Wise Engineering
3915 Old Fairground Rd.
Angier, NC 27501
(919)894-2203

Subject: The Hamilton Plan by H-Squared Home Design, Inc.

At your request, I reviewed the structural framing for the Hamilton Plan. Specifically, I reviewed the front porch support requirements.

FIRST FLOOR PLAN
 SCALE 1/4" = 1'-0"

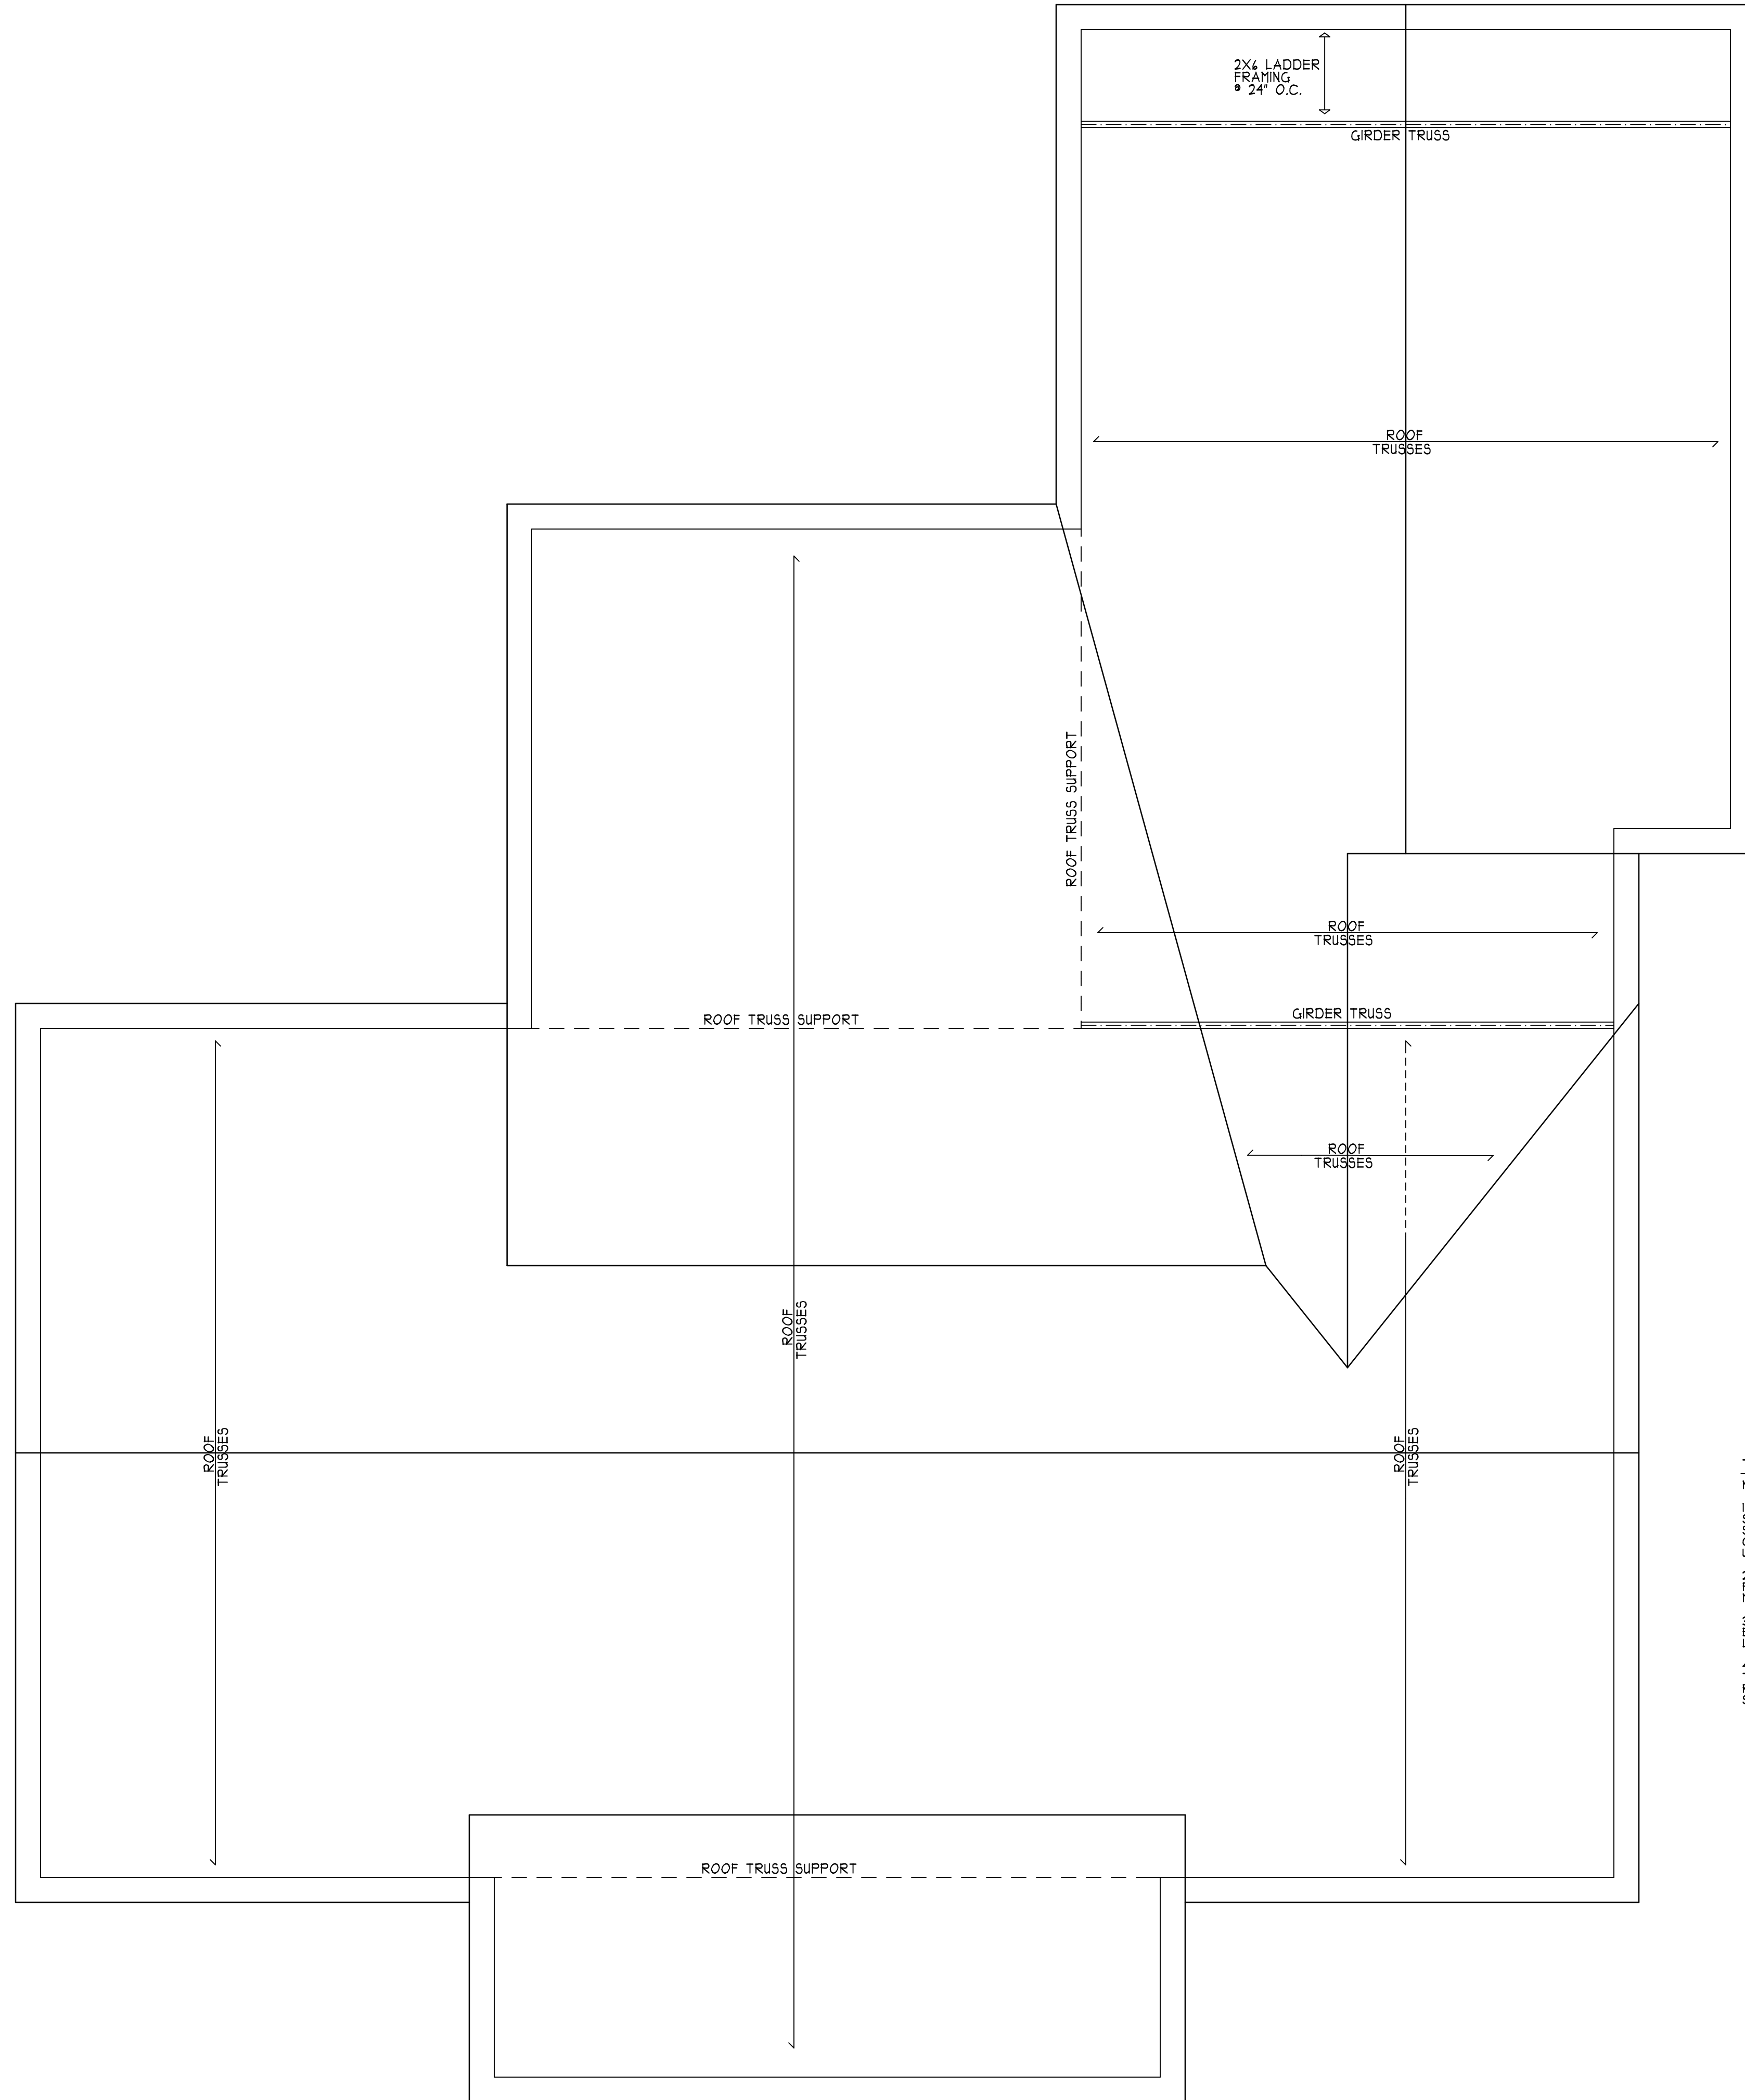
Based on my analysis, the truss design for the trusses in the center of the home bear on the front and back wall of the home as well as the back beam on the covered patio. The trusses are not actually supported on the front porch beam, as they are designed as a cantilever. Therefore, 4 x 4 posts are adequate to support the front porch beam, which supports the end of the trusses.
